27 February 2014

**North West Rail Link, Stage 2: Windsor Road Bridge Modification
(SSI5414 MOD1)**

Figure 5 - Elevation of the proposed modification

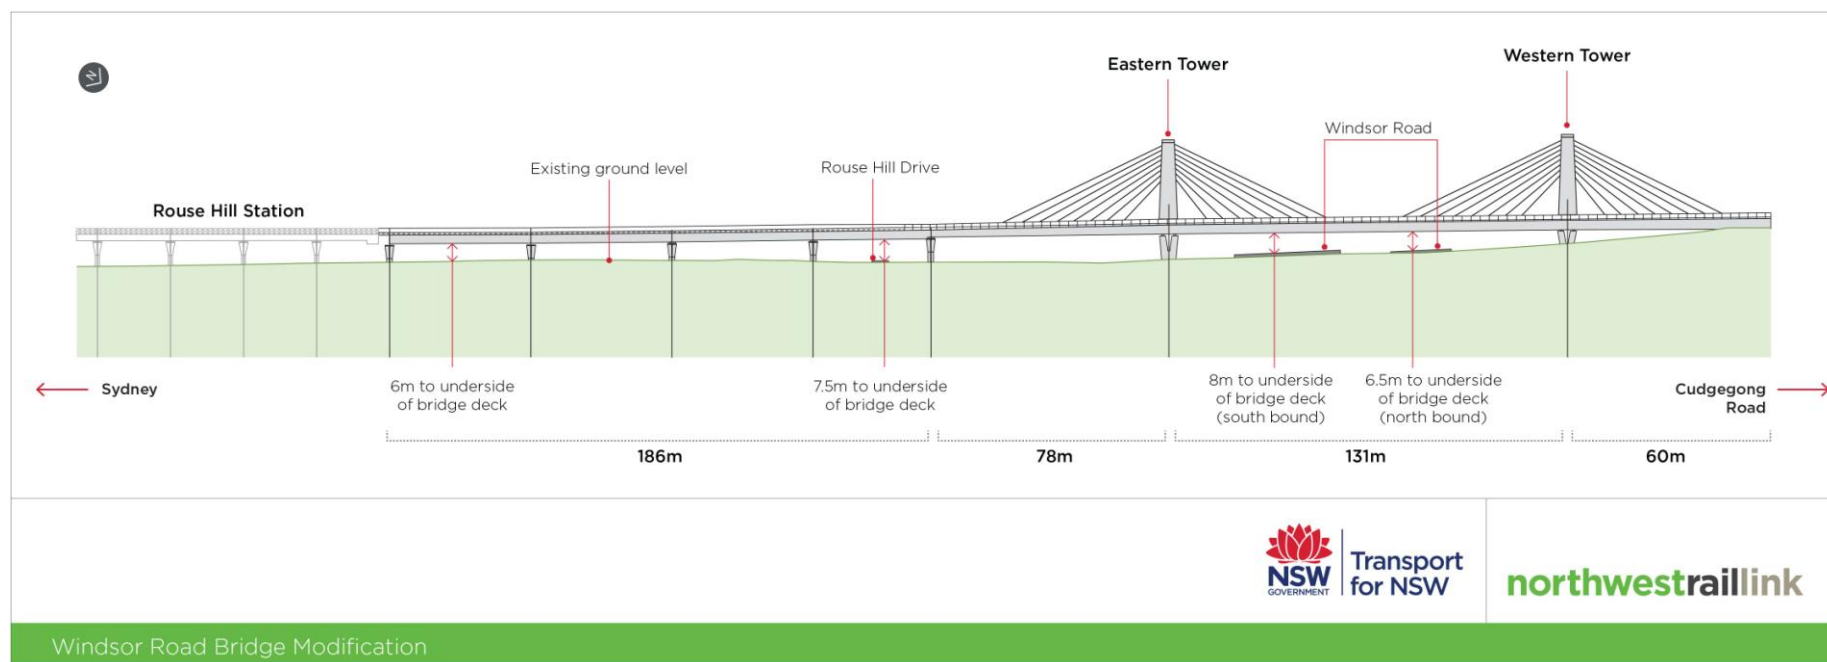
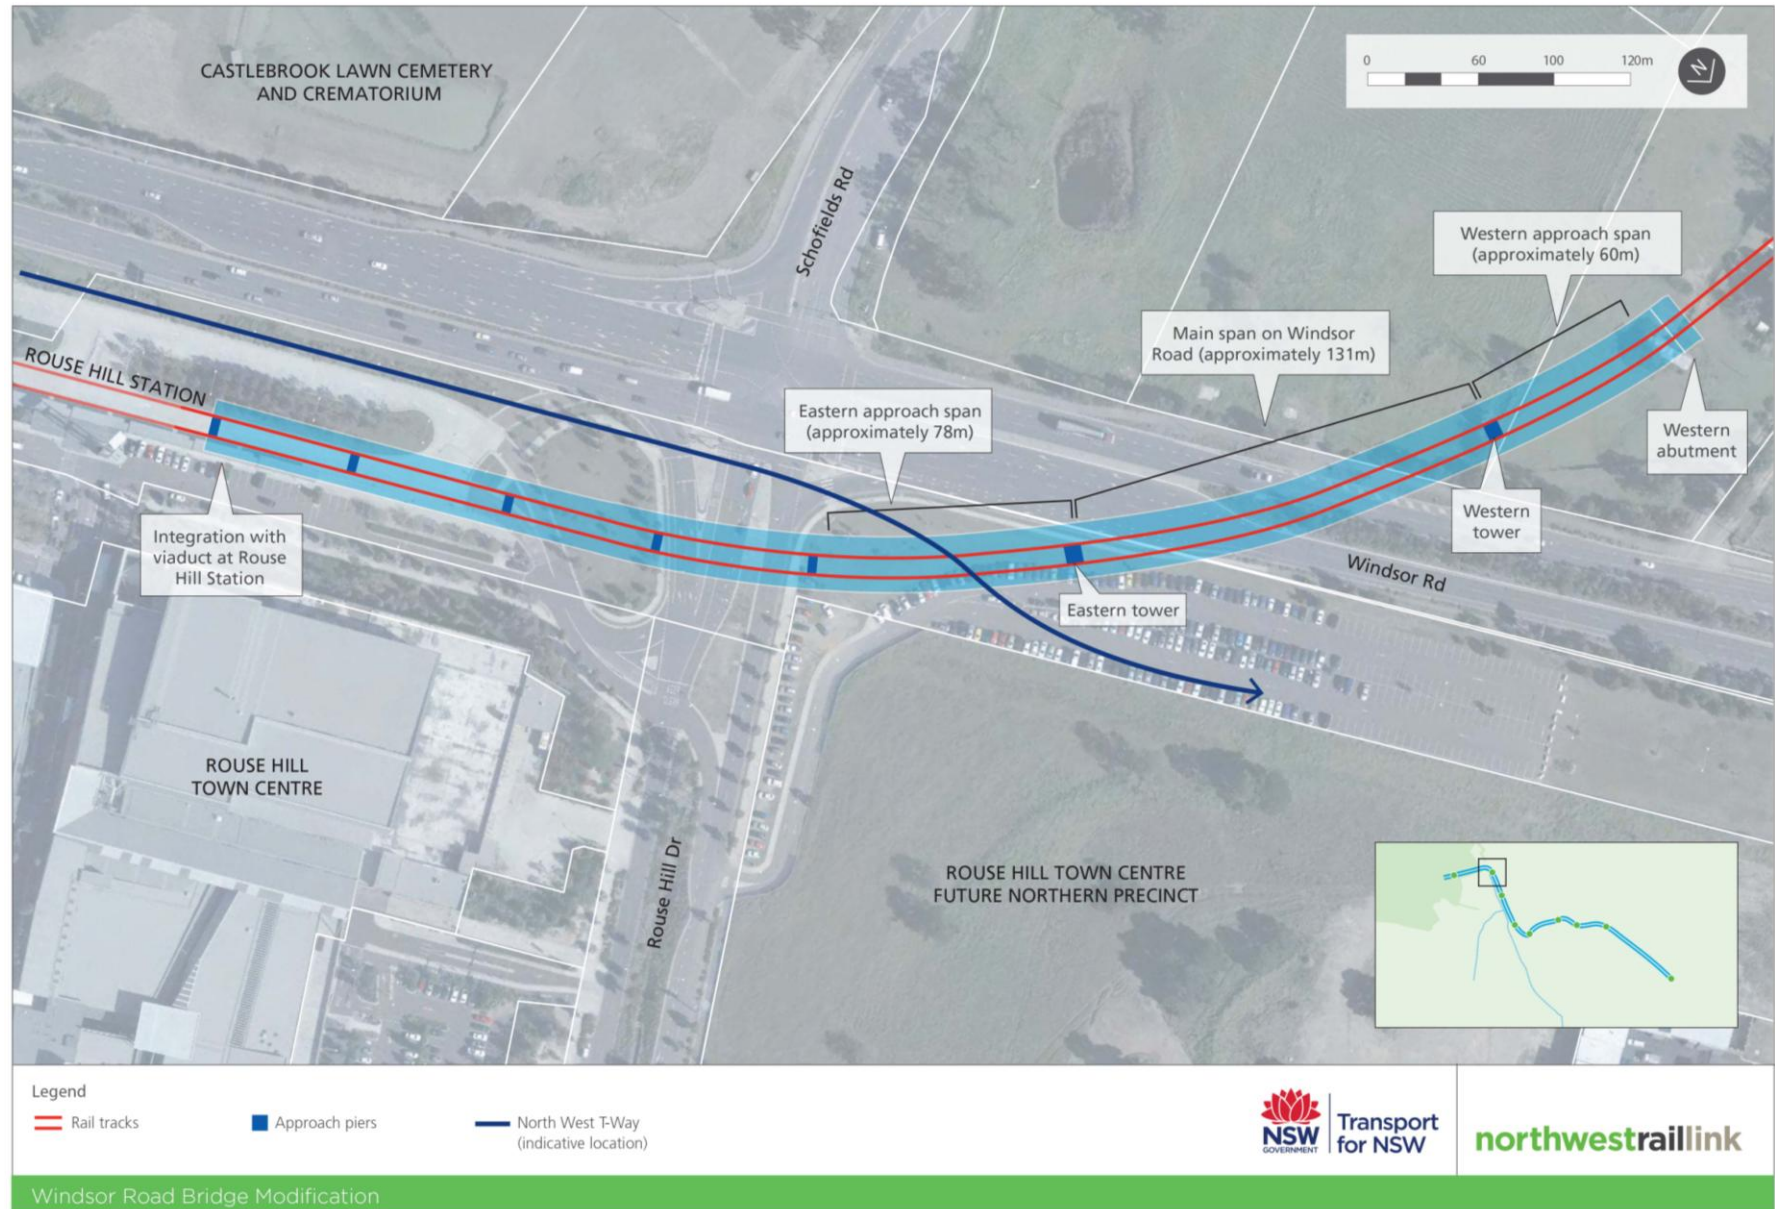
We would prefer to see a more visually appealing design, with structures that are reduced in height. We would therefore like to be part of discussions around the detailed architectural design of the bridge.

The longer bridge span may require longitudinal drainage pipes. These should also be considered when preparing the final designs in order to minimise their visual impact.

The proposed western end span of 60m is supported as it should provide sufficient space to permit a local road connection underneath and maintain access within the Area 20 Precinct. This is an important link for the south-east corner of the Precinct and needs to be maintained.
